**EL PASO COUNTY PLANNING AND
 COMMUNITY DEVELOPMENT
 DEPARTMENT**

STORMWATER MANAGEMENT PLAN CHECKLIST

Revised: July 2019

SITE MAP AND LOT OWNERSHIP

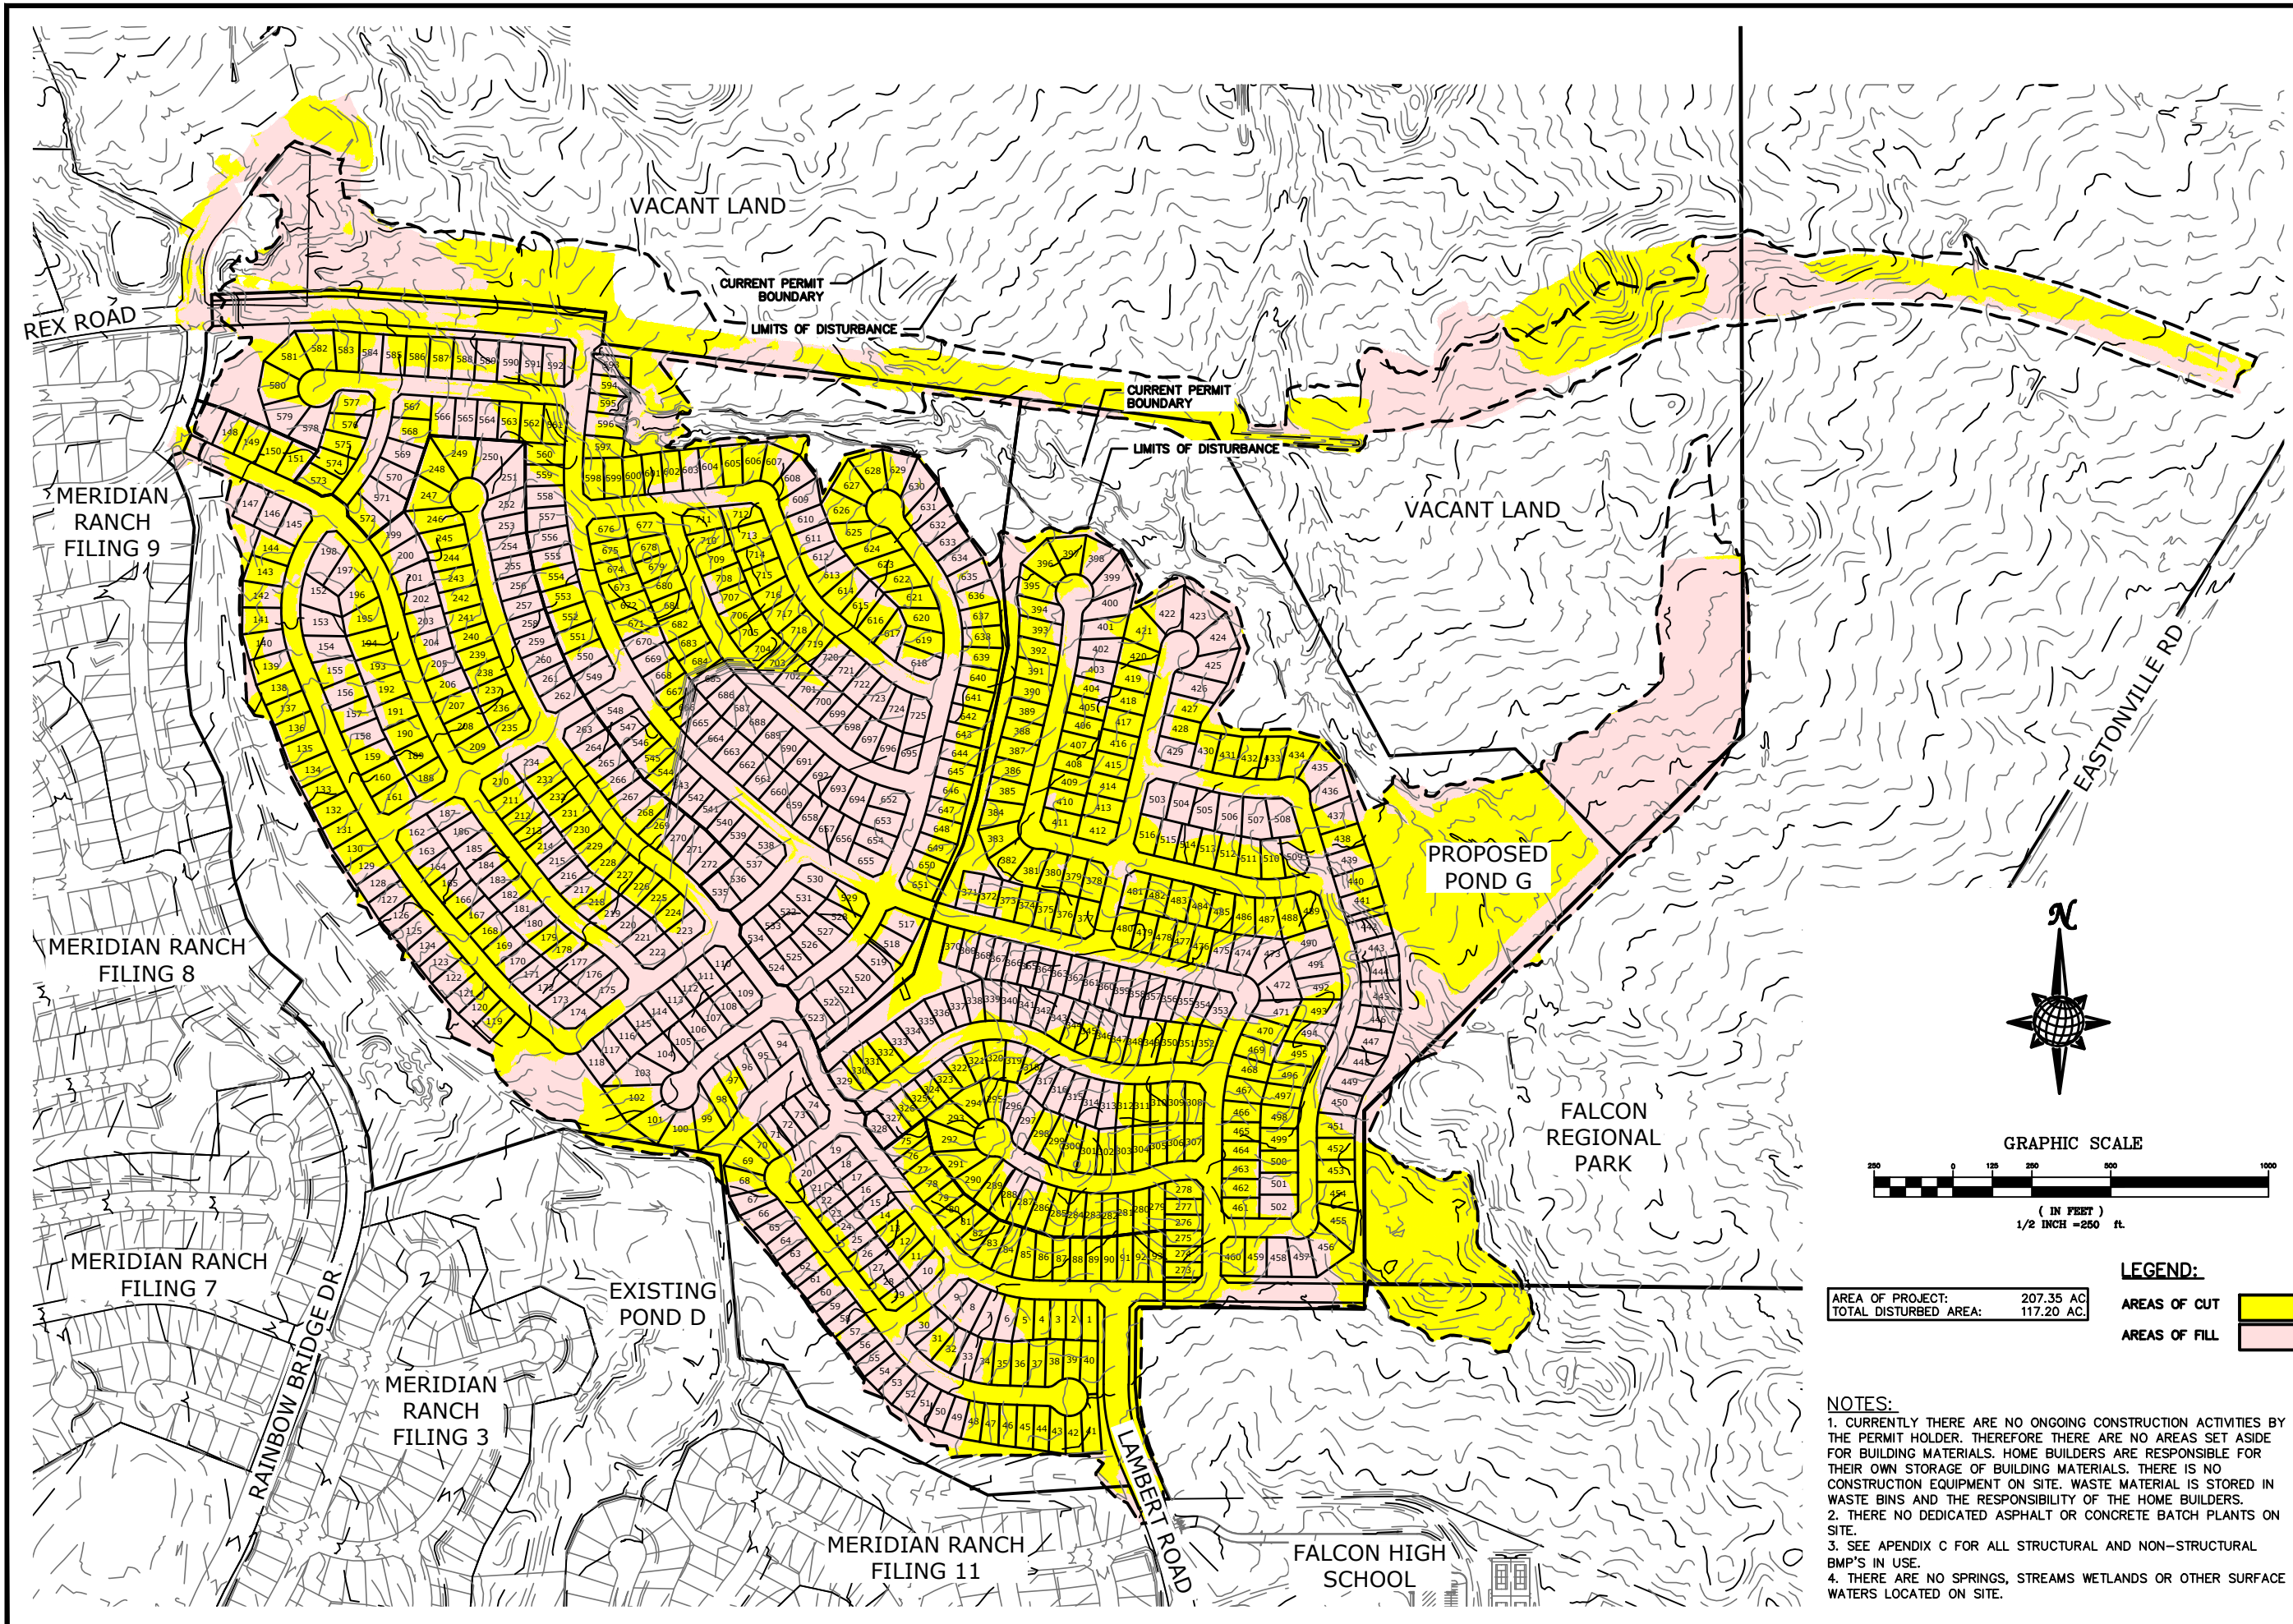
Please show or provide a statement that this will determined at a later date. Coordinate with Note 1. shown on the SWMP Site Map included in Appendices A and B.
